Response to Submissions

Prepared for: **Grand Noble Project 1 Pty Ltd**

The State Significant Development Application (SSD-96272465) for residential development with in-fill affordable housing at 11–23 Rangers Avenue, Mosman was publicly exhibited between 4 December 2025 and 17 December 2025. During the exhibition period, a total of 185 submissions were received.

1. HEIGHT PLANE DIAGRAM - SOUTH-WESTERN CORNER

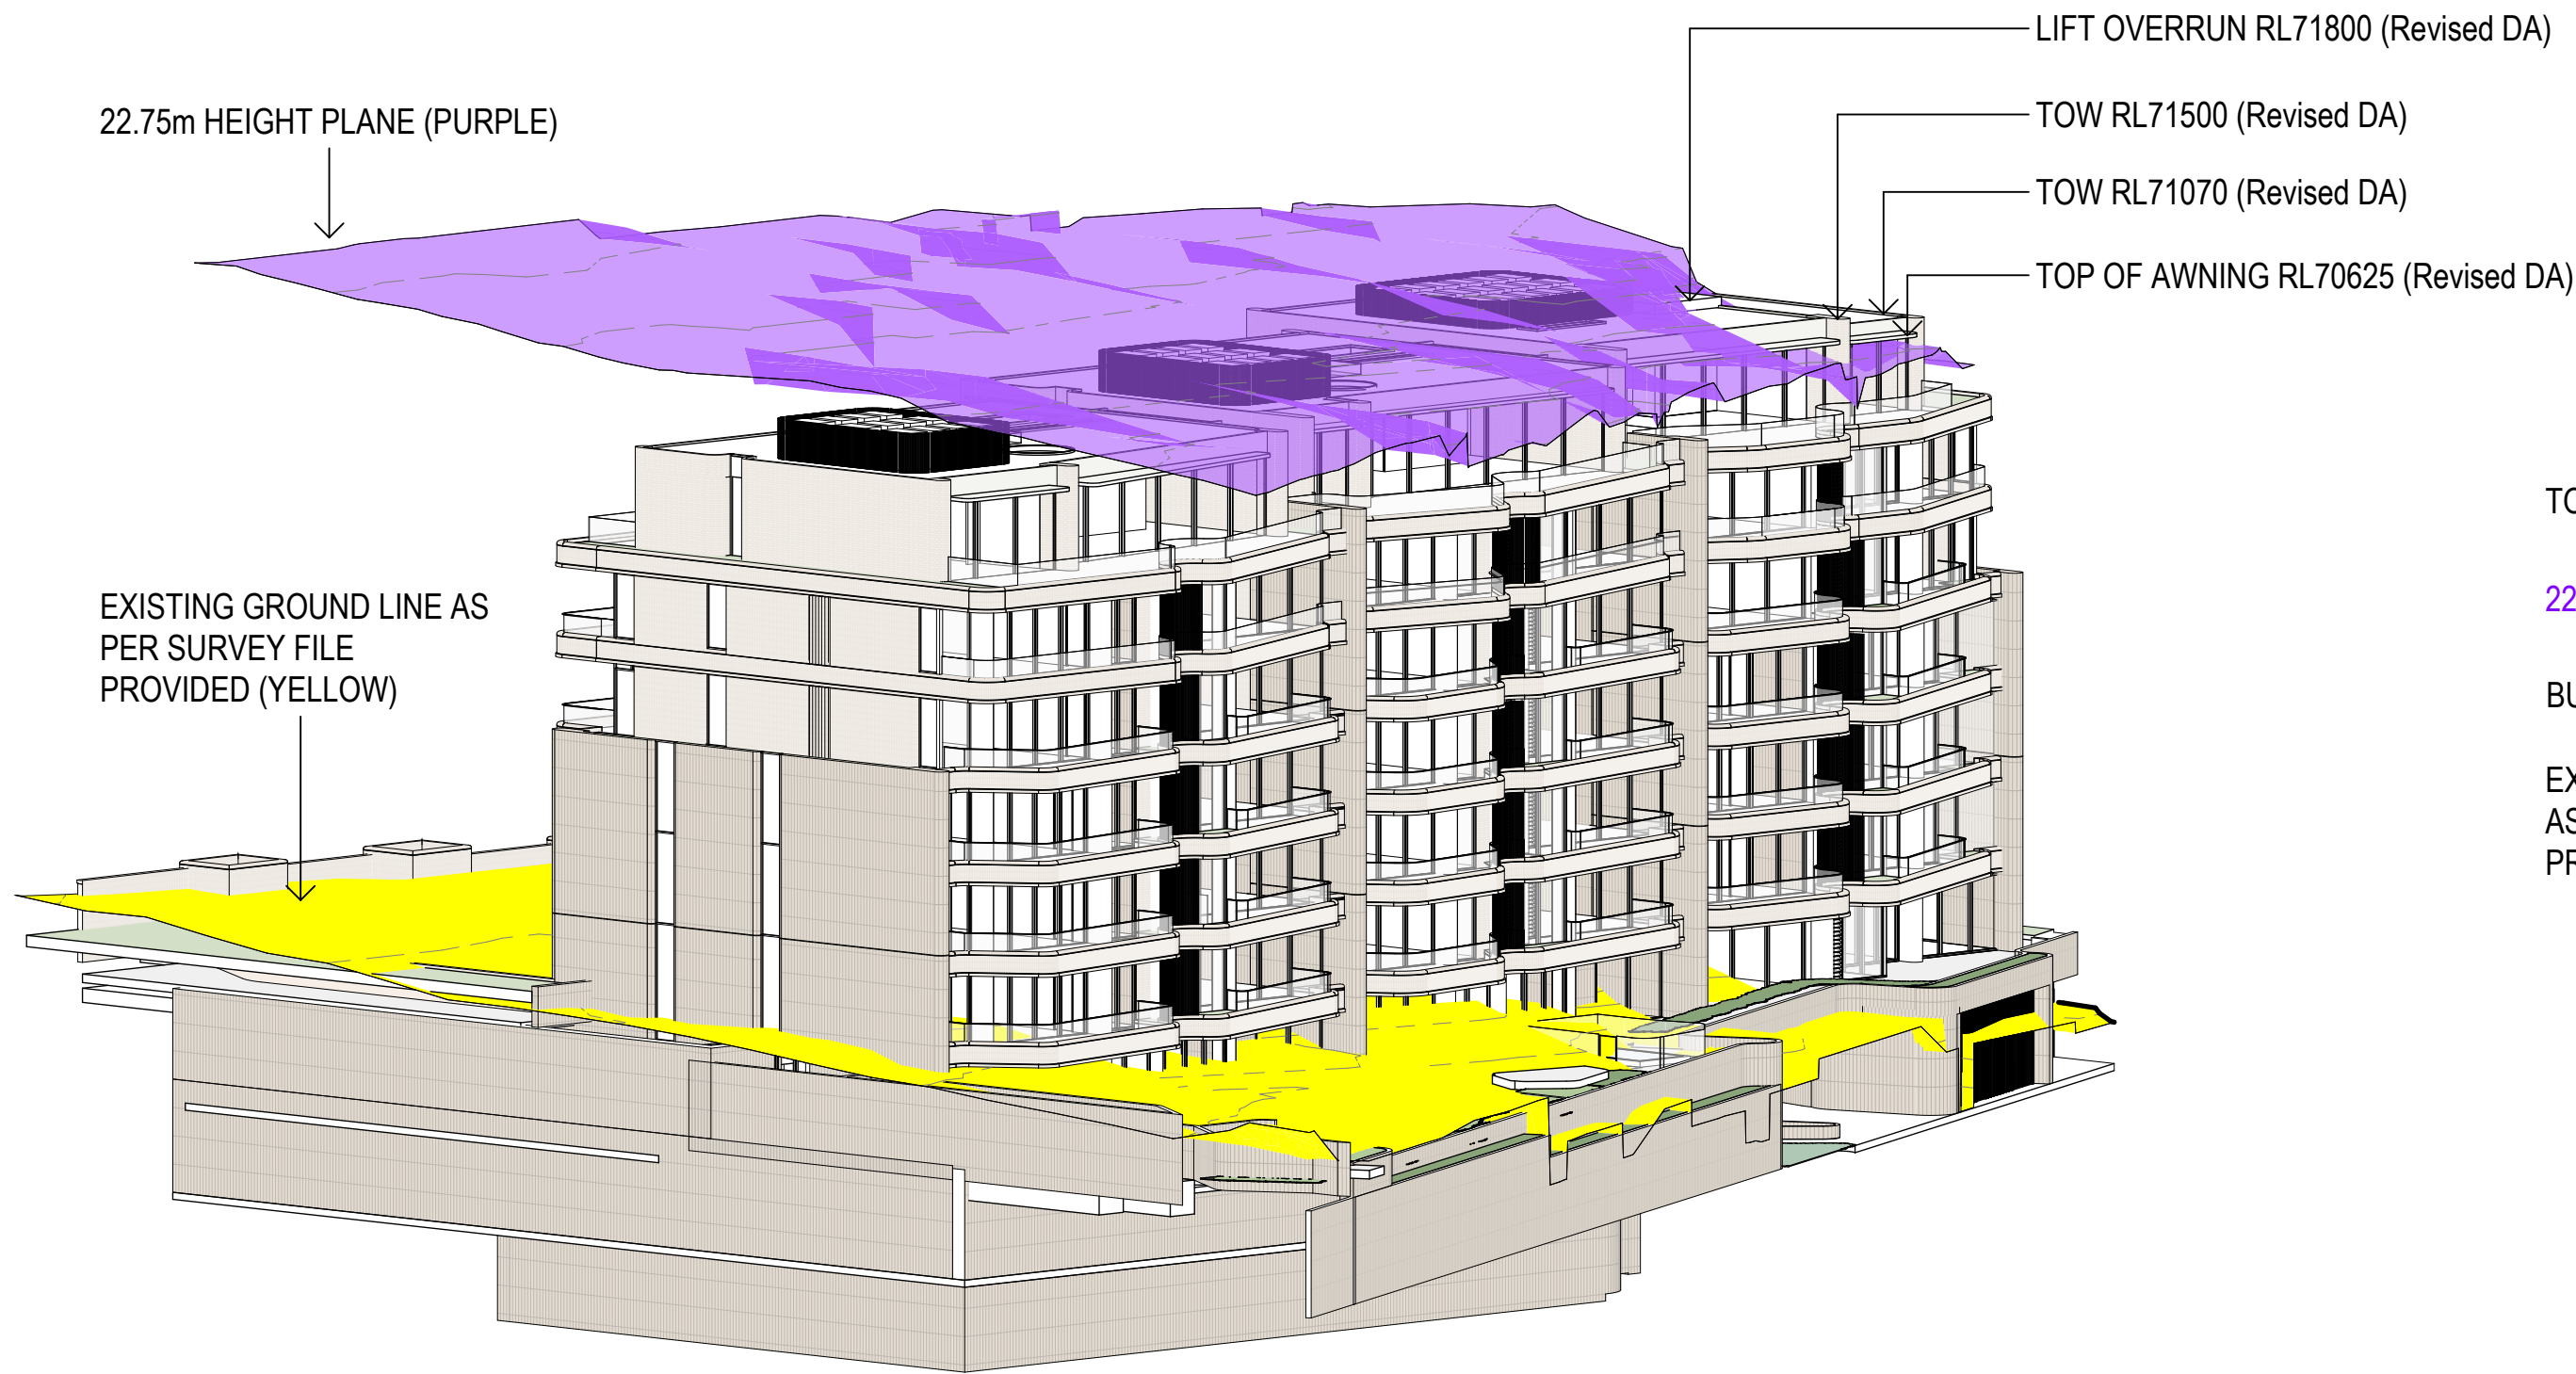
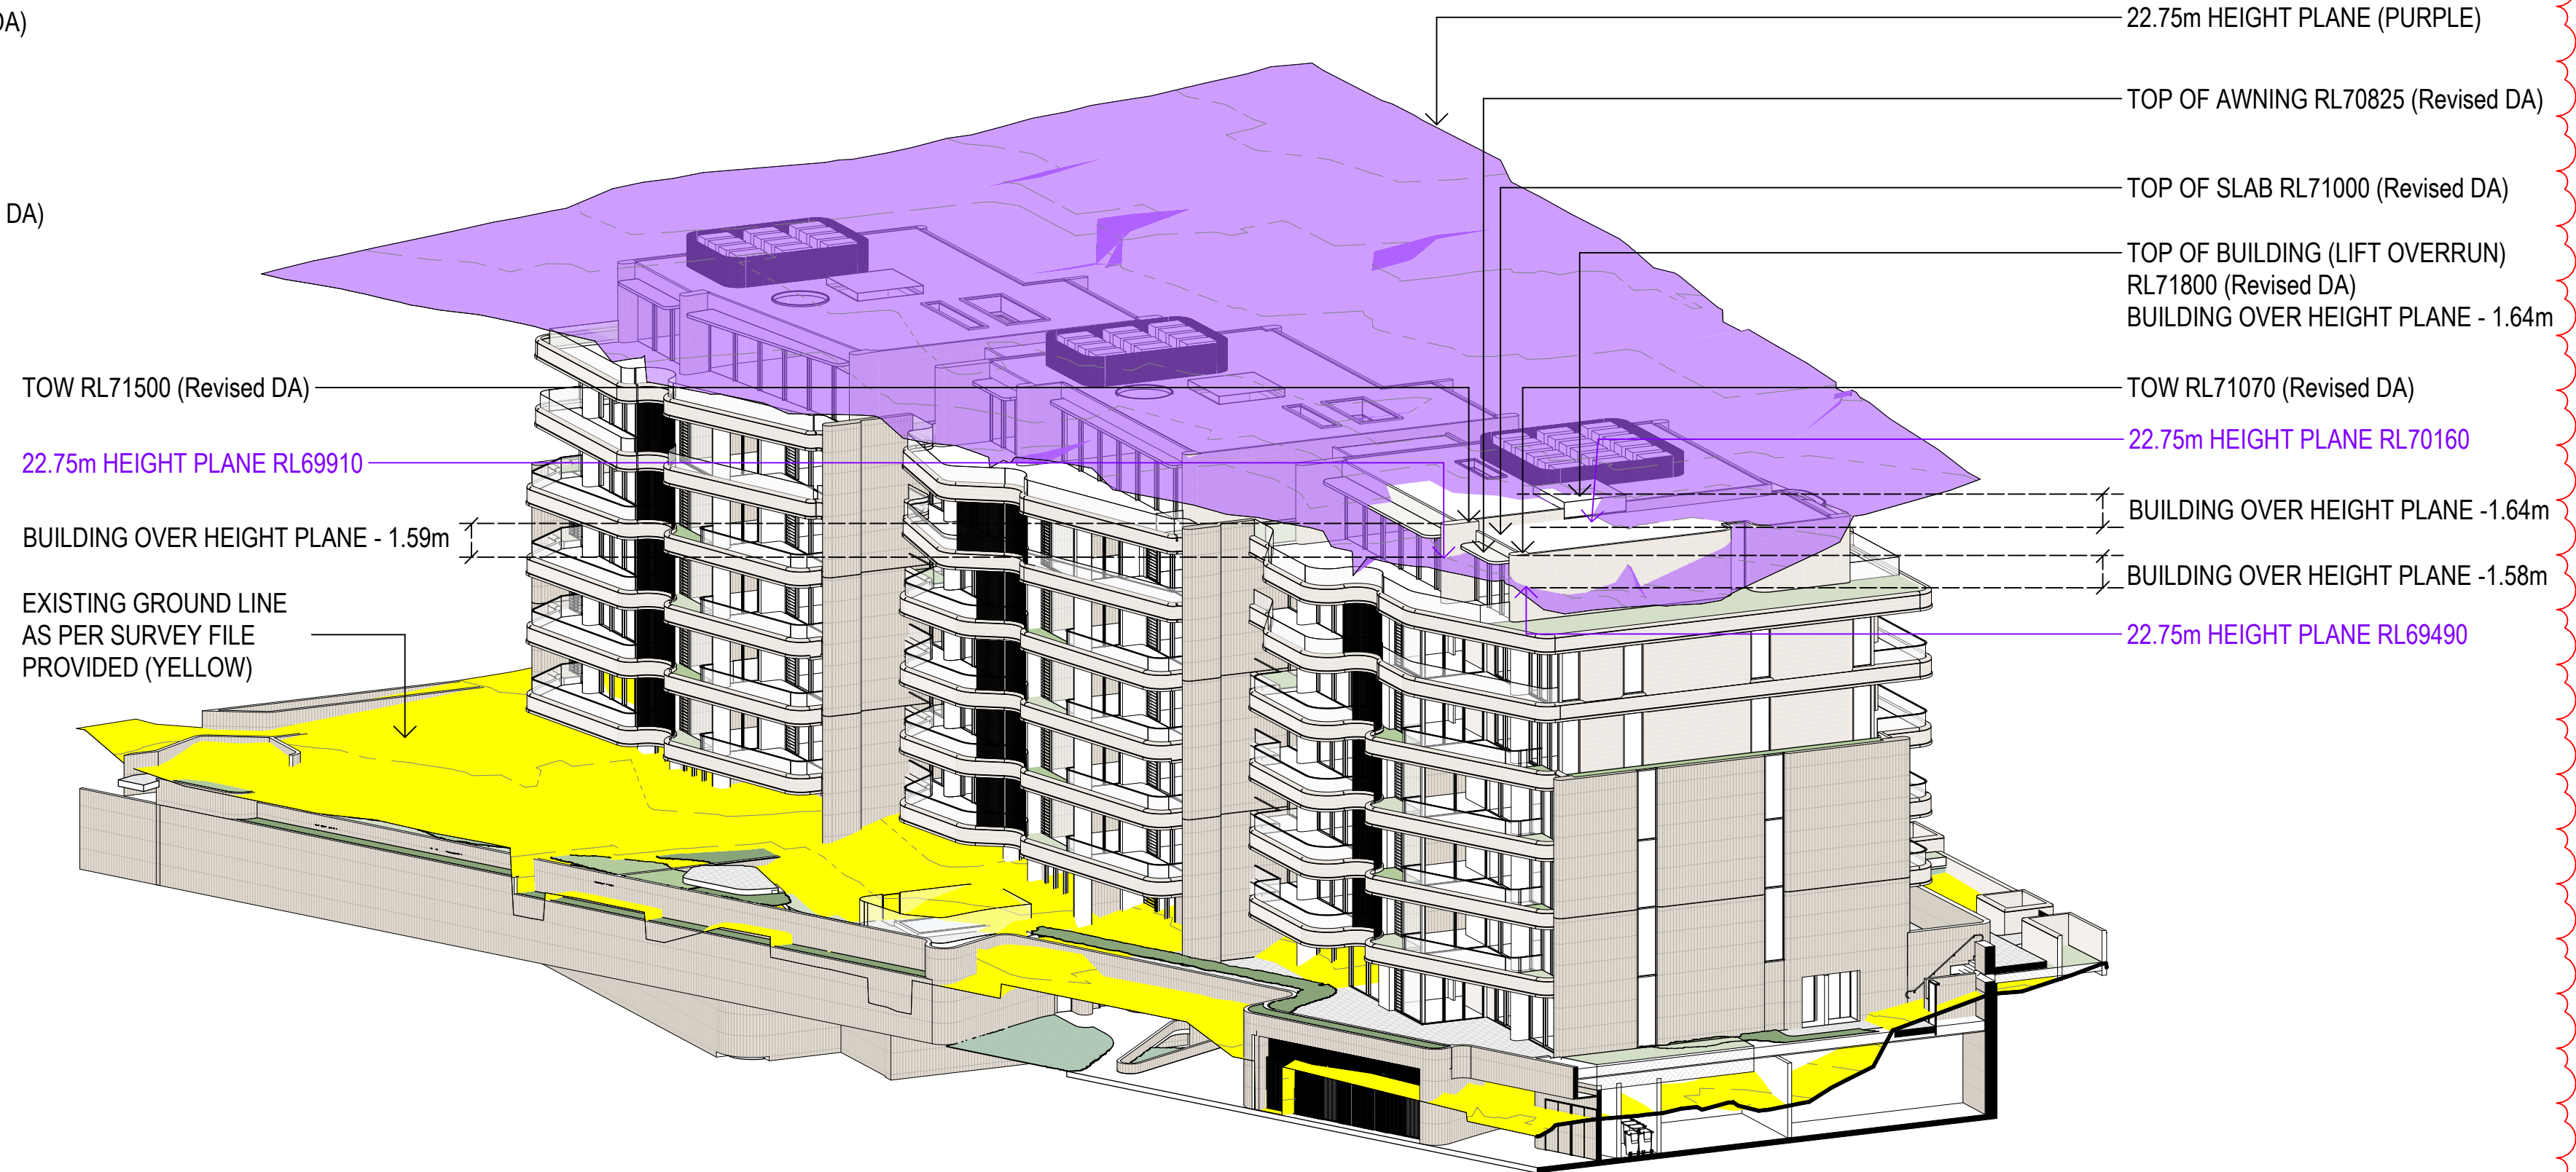
- Identifies non-compliance with building height and wall height controls, stating the development exceeds the maximum height even with the affordable housing uplift, and contending the proposal’s height presentation is amplified by slope and excavation.
